RE: NSW EPA AND DPIE REQUEST FOR ADDITIONAL INFORMATION – PROPOSED RESOURCE RECOVERY FACILITY (RRF), 16 TORRENS ROAD, GUNNEDAH

Martens have reviewed the request for additional information (RFI) provided by NSW Department of Planning, Industry and Environment (NSW DPIE), NSW Environment Protection Agency (NSW EPA) and Gunnedah Shire Council (GSC), and provide the following response and additional detail:

DRAWING TITLE				
DRAINAGE DETAILS				
PROJECT NO.	PLANSET NO.	RELEASE NO.	DRAWING NO.	REVISION
P1907434	PS01	R16	PS01-E200	B

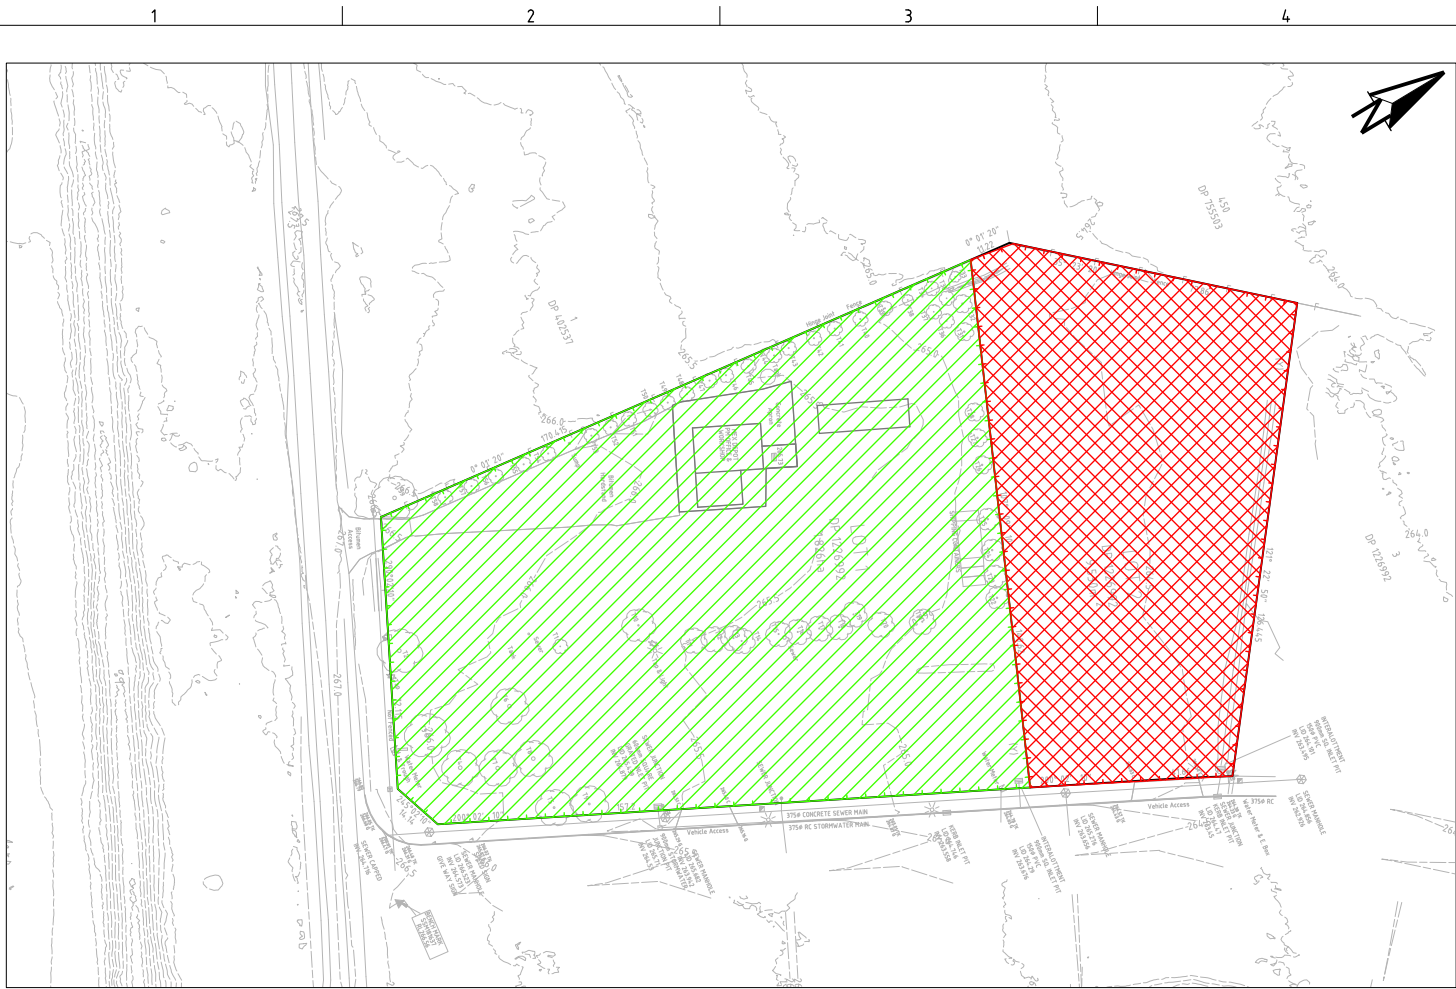
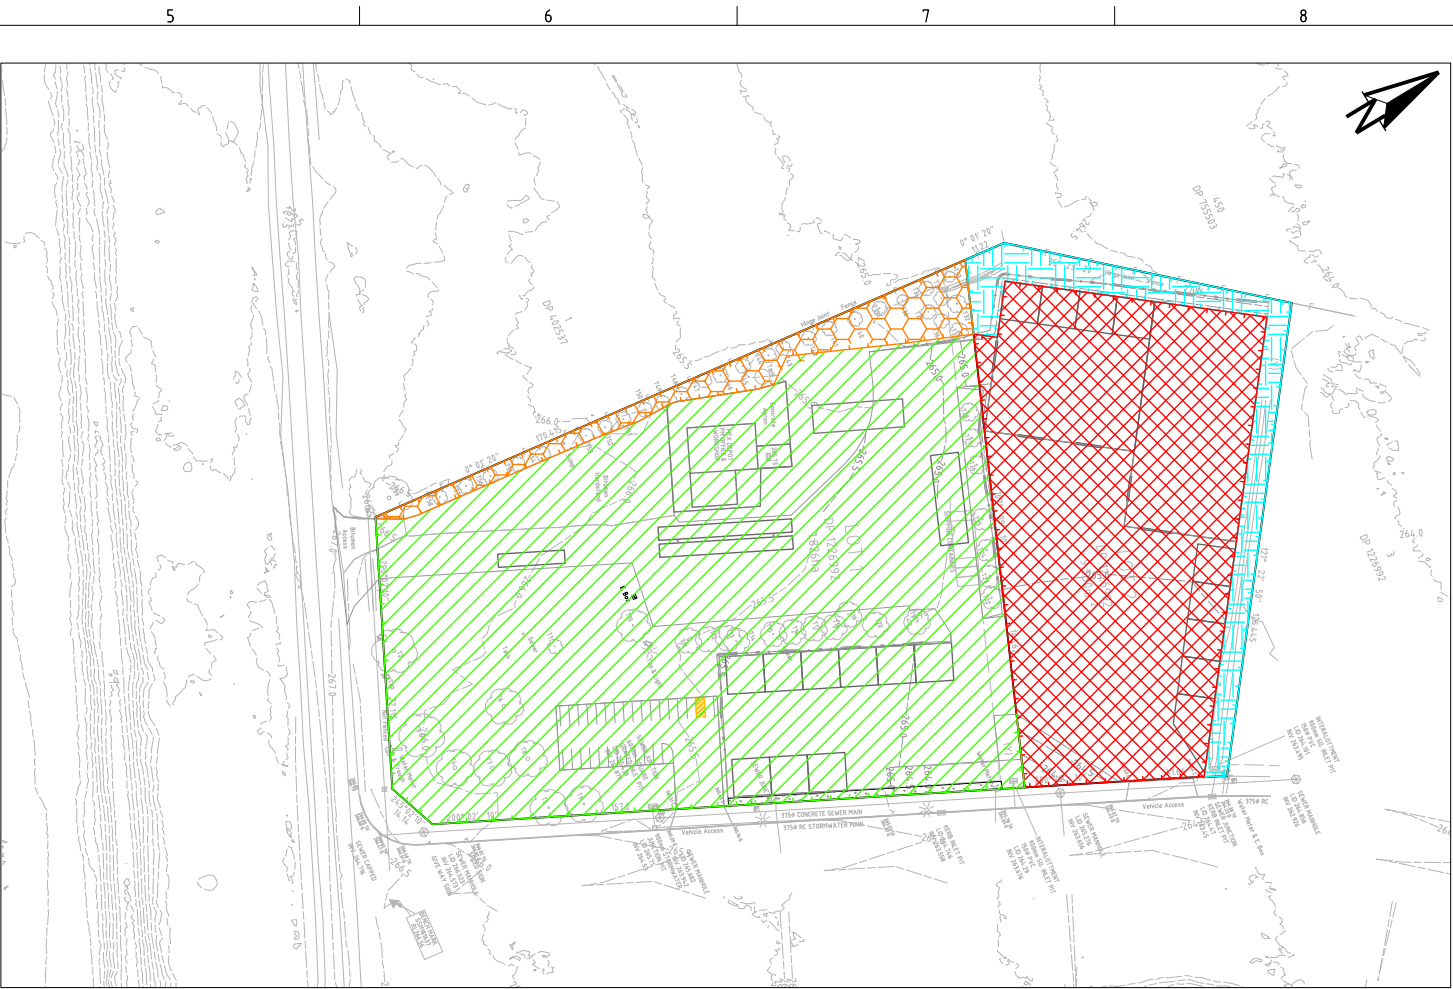
Provide details of the measures to contain fire water run-off noting that in addition to four hydrants there is a requirement for a sprinkler system.

5. Specific measures to contain fire water runoff shall include:
 - a. Automated and manually operated valves on all outlets from site OSD tanks to retain fire water within tanks and prevent offsite movement of fire water to Council's stormwater drainage network.

- b. Bunds to be provided around yard areas (in the form of trafficable humps). These shall provide an above ground storage volume of the order of 600 kL on Lot 1 and 500 kL on Lot 2 (subject to final site grading and height of bunds). Combined with OSD tank volumes, this shall provide of the order of 1.5 ML of fire water storage on site.

- c. Bunds shall also be provided within site buildings to contain firewater. The minimum volume to be contained in each building shall be 130 kL (based on 2 hour operation of 18 sprinklers at 1 L/s/sprinkler in accordance with AS 2118.1 (2017)).

The above elements are noted in Attachment A, drawings E100 and E200 (ref: P1907434PS01-E100 and E200).

DRAWING ID: P1907434-PS01-R16-F300

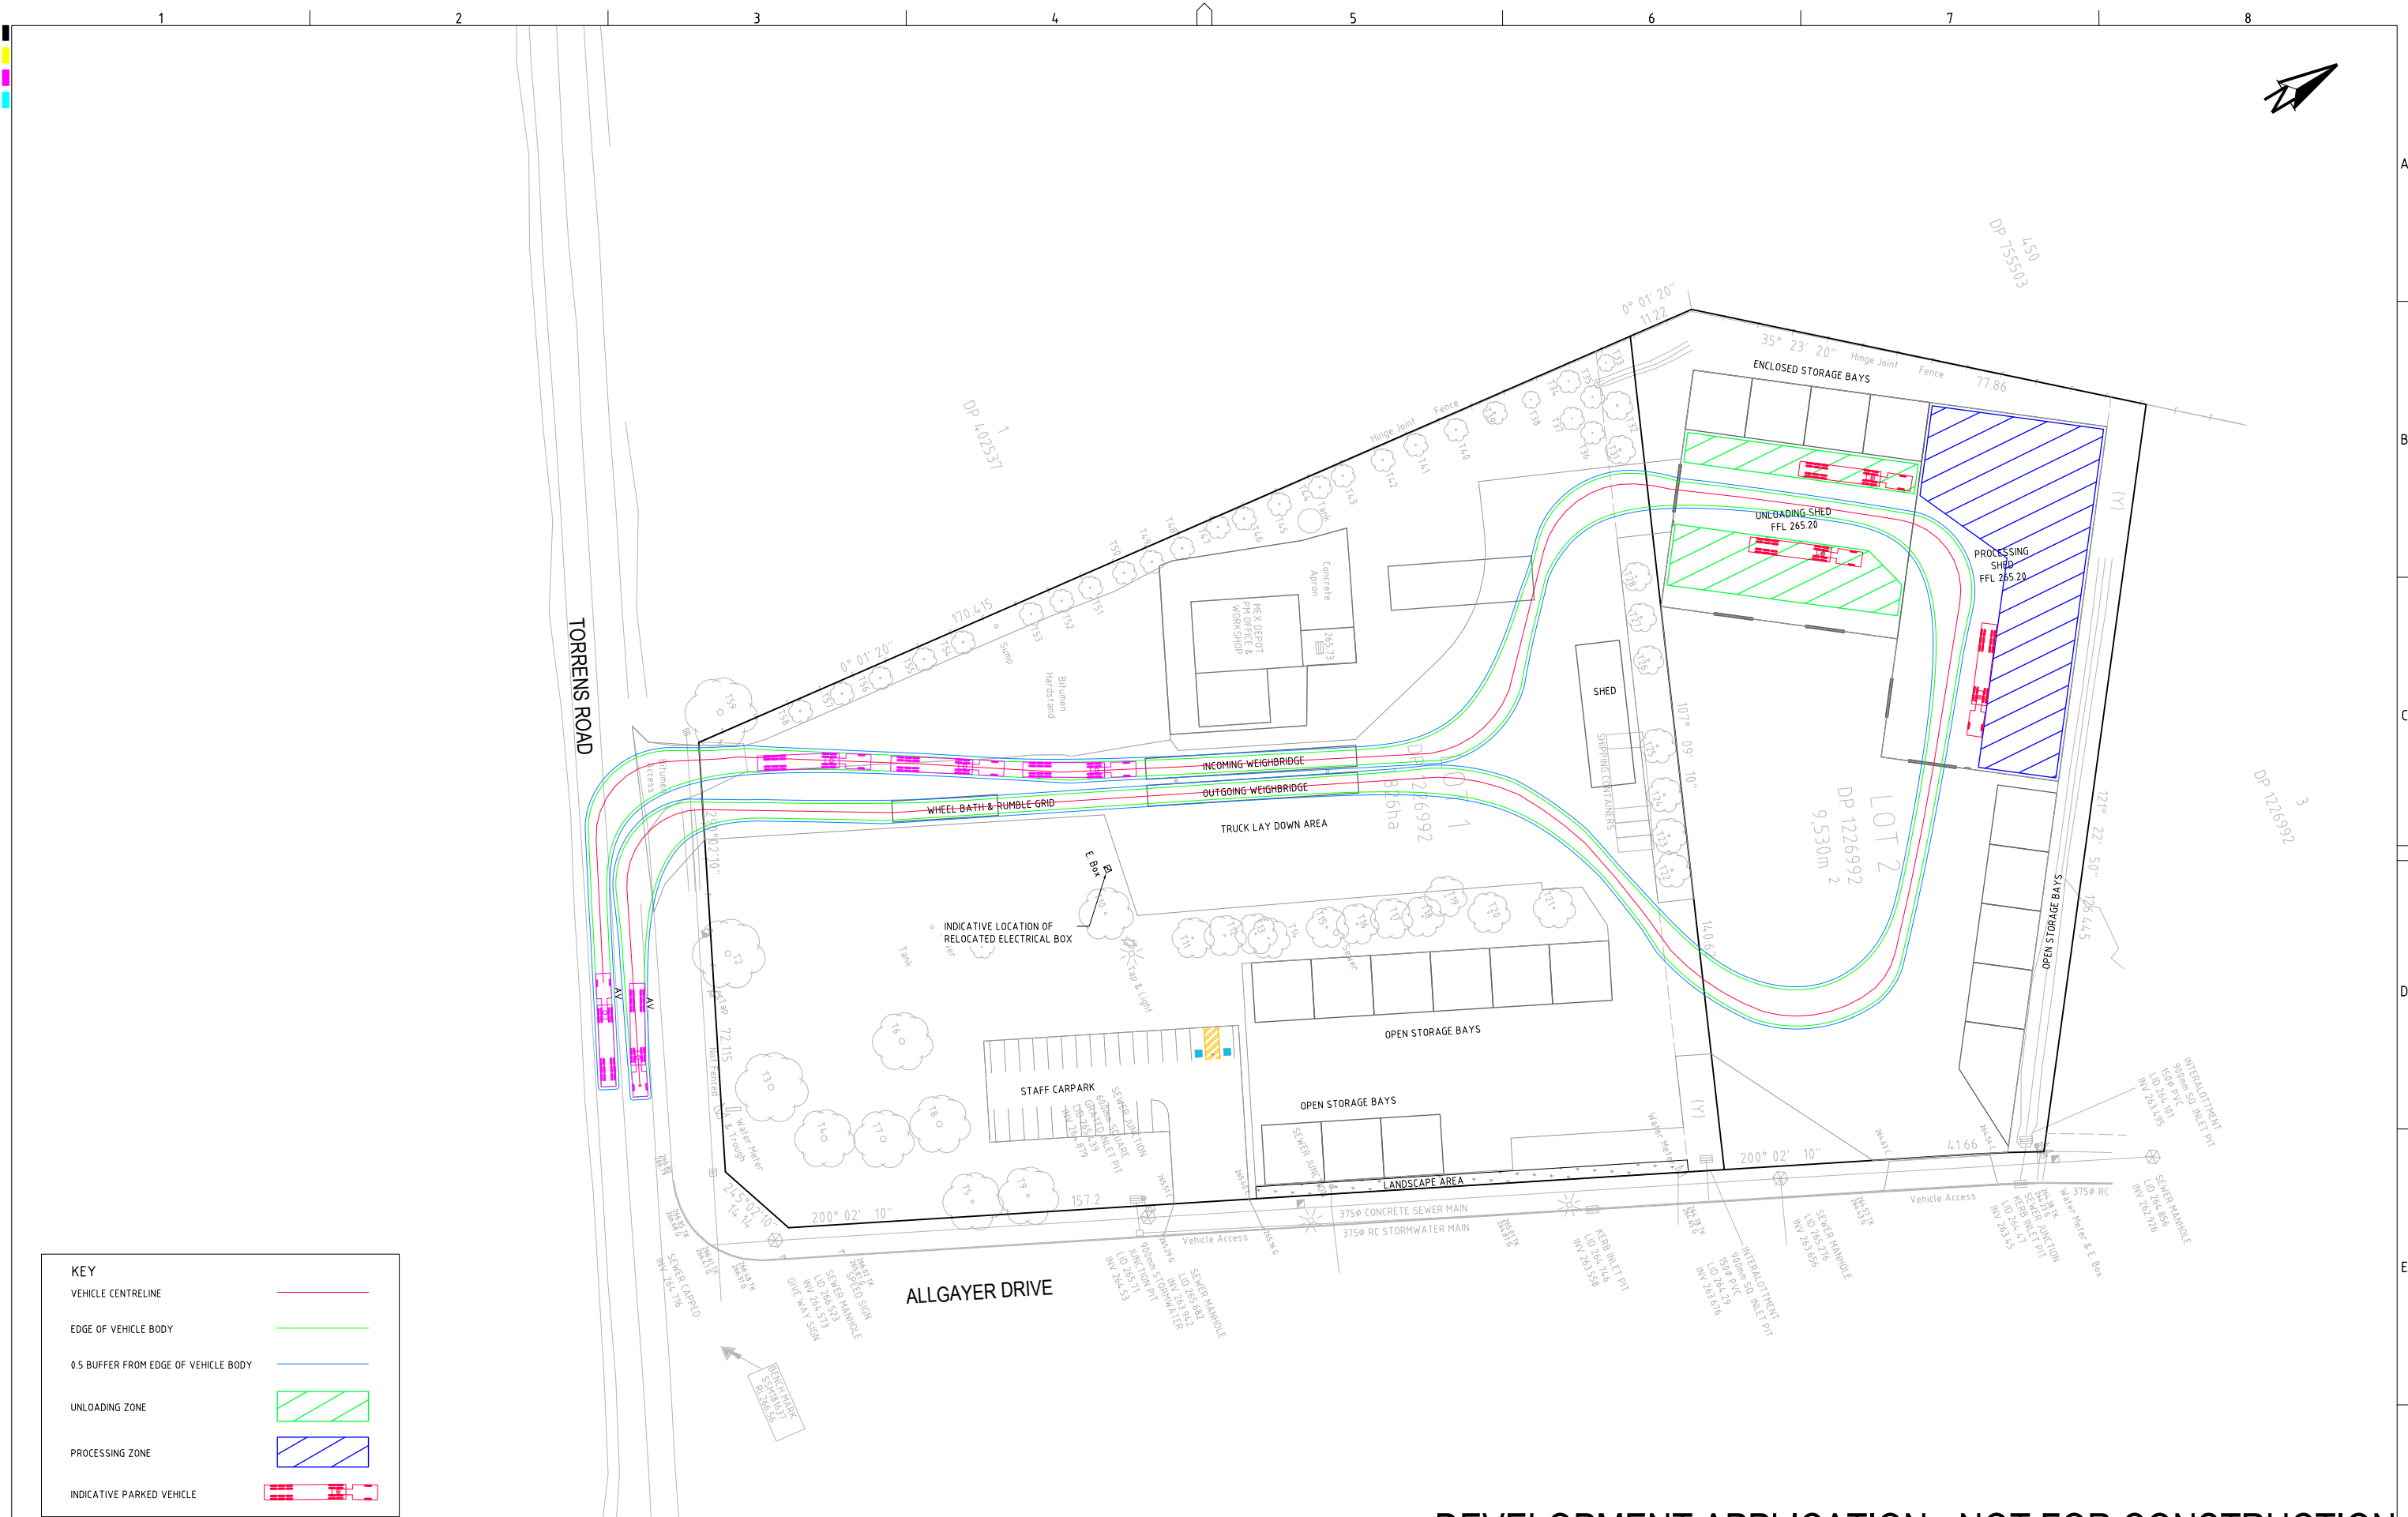
Provide a plan showing the location of all proposed fire hydrants noting these must be more than 10m from stockpiles and accessible for firefighters entering the site.

Provide details of all sprinkler and hydrant systems including flow rate and capacity and details of the smoke exhaust system.

1. Site fire fighting system shall be connected to Council potable water supply mains located in the Torrens Road and Allgayer Drive road reserves. Site internal water supply main shall be a ring main configuration to avoid dead ends where feasible. Hydrants shall be placed such that they are not closer than 10 m from any stockpiles and shall be accessible from site hardstand areas to allow for a firefighting vehicle to access the hydrant. Sizing of the internal firefighting water supply main shall be undertaken at detailed design stage of the development. A conceptual layout showing position of proposed site hydrants is provided in Attachment A, drawing F300 (ref: P1907434PS01-F300).

2. Review of AS 2419.1 (2017) has determined that for each lot 2 hydrants operating simultaneously at 10 L/s shall be required based on yard area of less than 9,000 m². This equates to a requirement of 20 L/s (144 kL/hour) for fire hydrants on each lot.

3. In addition, the unloading and processing sheds on Lot 2 are required to have a sprinkler system installed to Australian Standard 2118.1 (2017). Review of AS 2118.1 (2017) shows that the proposed RRF would be classified as an 'Ordinary Hazard 3 (OH3)' and therefore requires 18 sprinklers operating simultaneously at 1 L/s/sprinkler (18 L/s total or 64.8 kL/hr).

PROJECT NO. P1907434
												PLANSET NO. PS01
												RELEASE NO. R16
												DRAWING NO. PS01-A300
												REVISION L

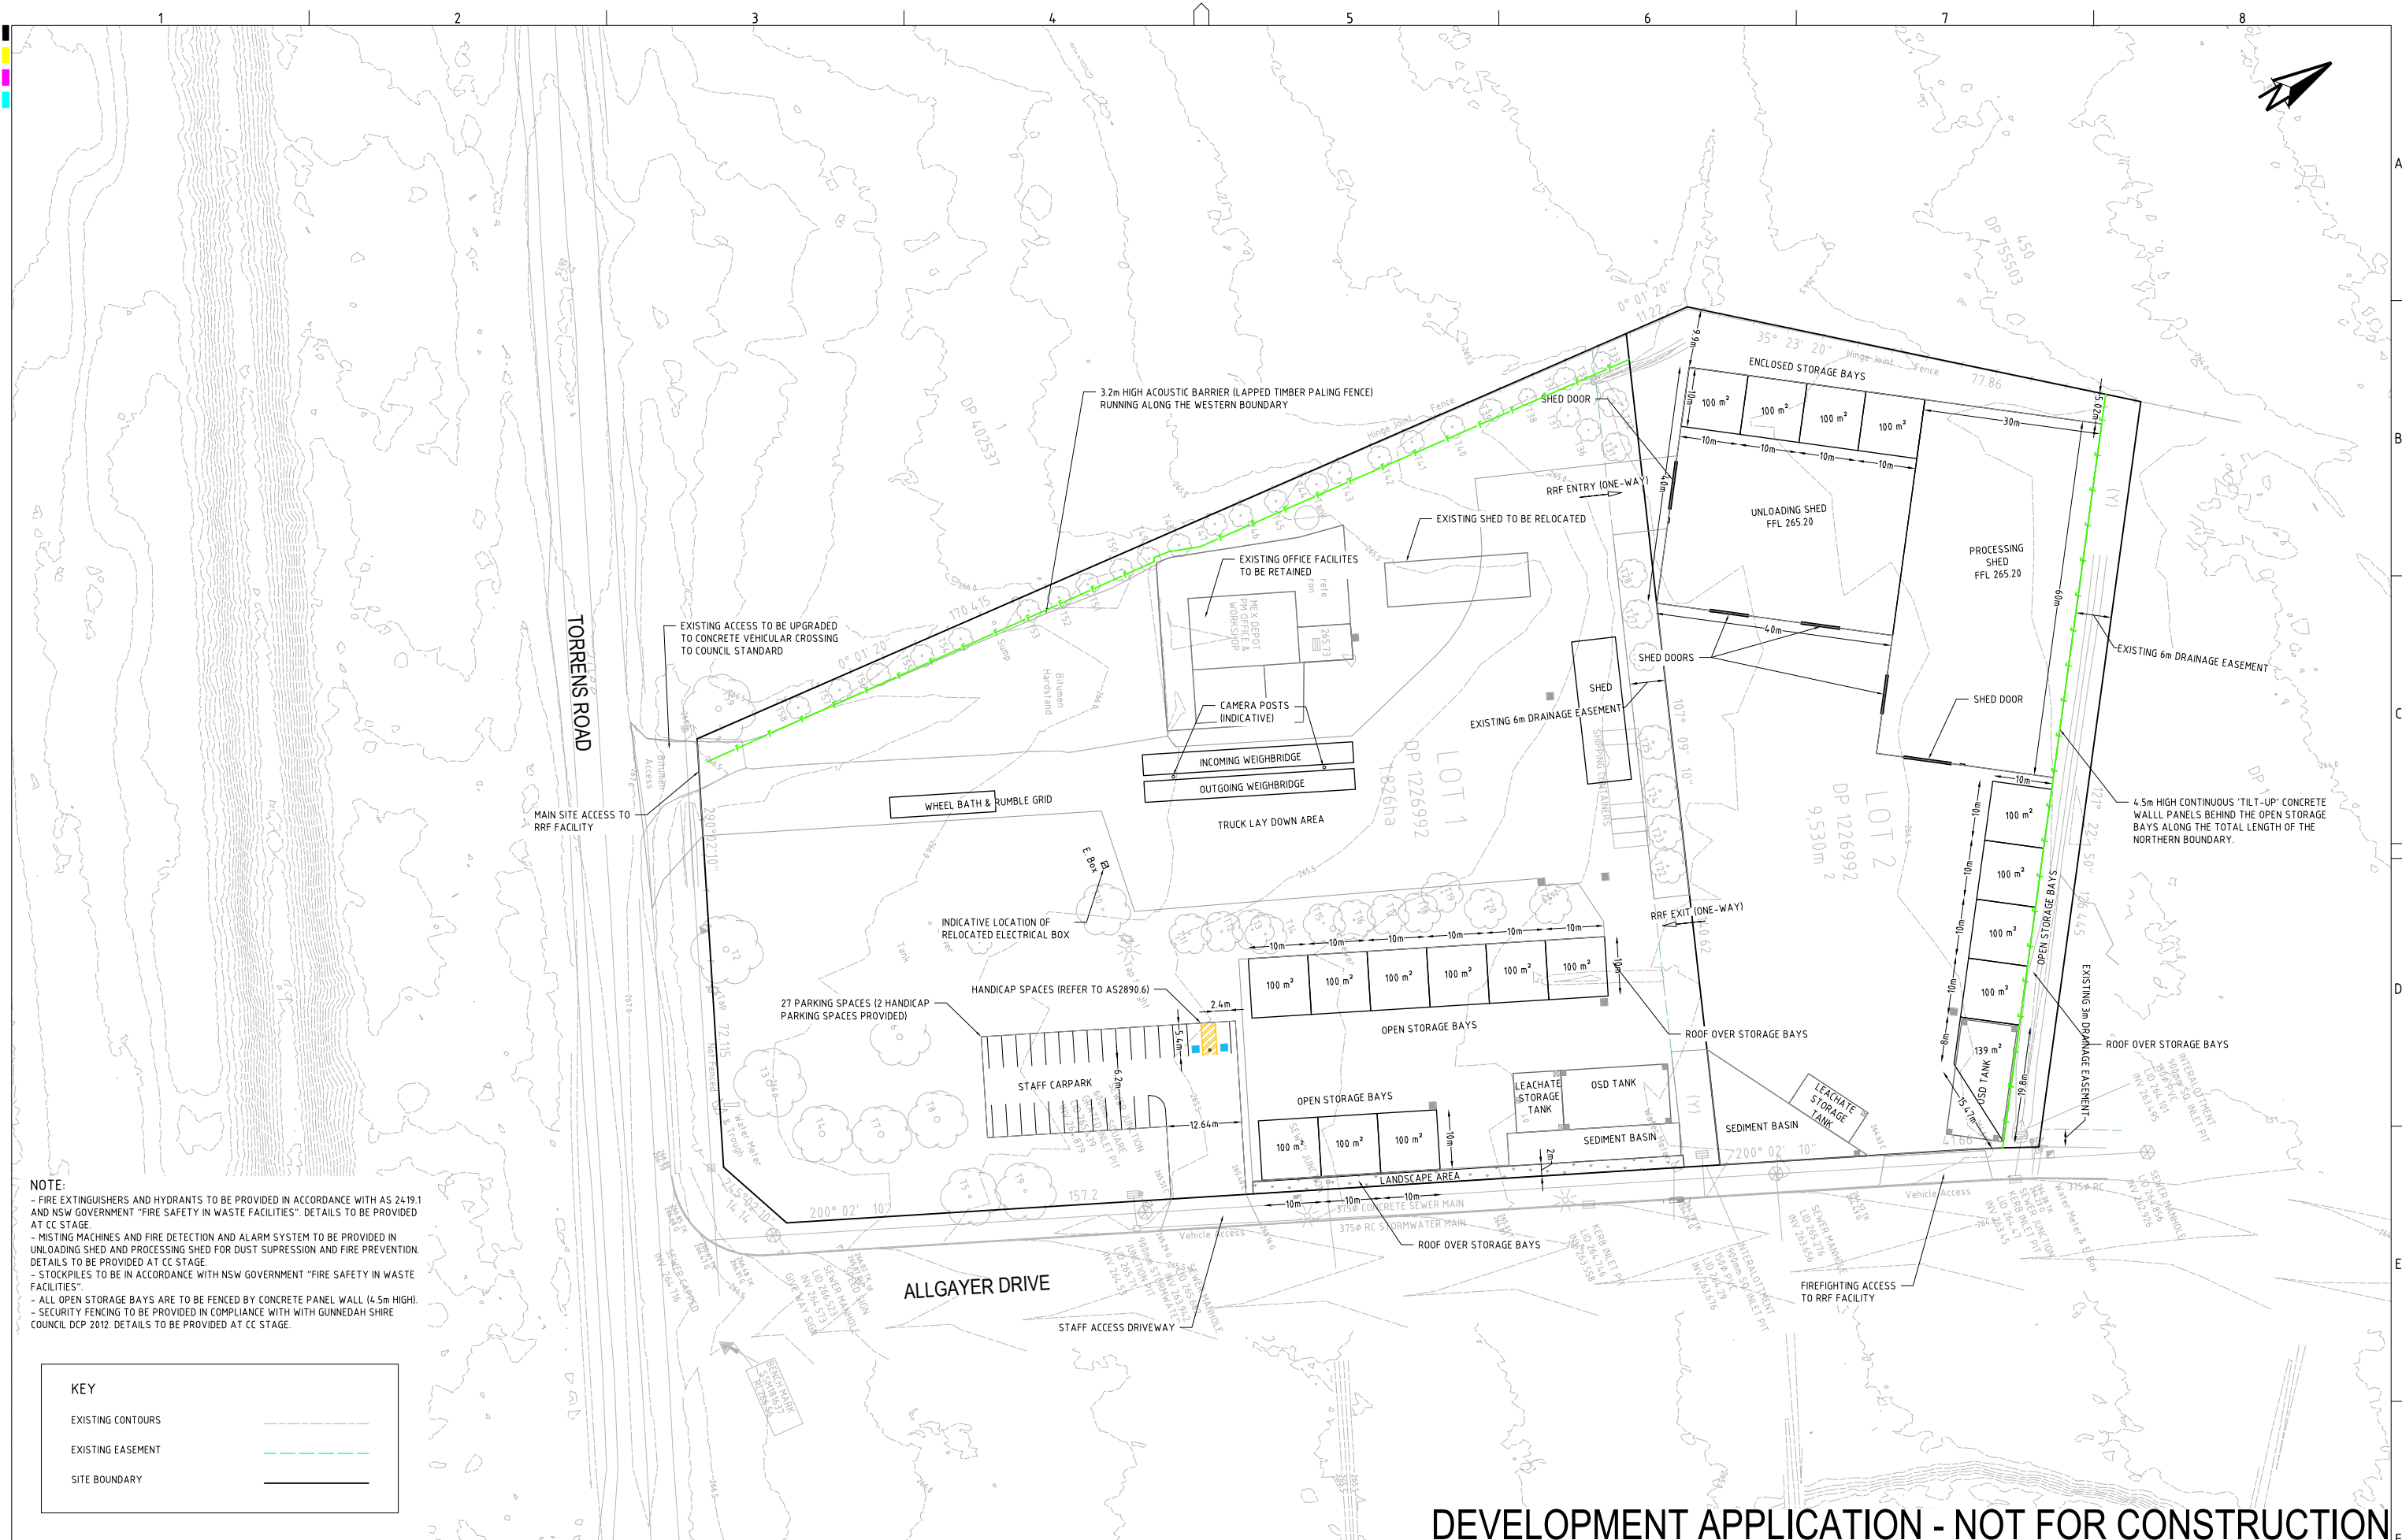
The development has not adequately addressed onsite parking demand for the lands proposed additional land use. Parking for this development should be in addition to existing parking requirements. Council requests that a detailed parking layout, complying with AS2890.1 be prepared and submitted as part of this development, accommodating the minimum number of spaces required onsite.

The proposed staff carpark provides 27 parking spaces (including 2 handicap spaces) and is to be accessed via the existing vehicular access from Allgayer Drive. All parking spaces and aisles comply with AS2890.1 and AS2890.6.

Refer to Attachment A, drawing A300 (ref: P1907434PS01-A300) for details of staff carpark.
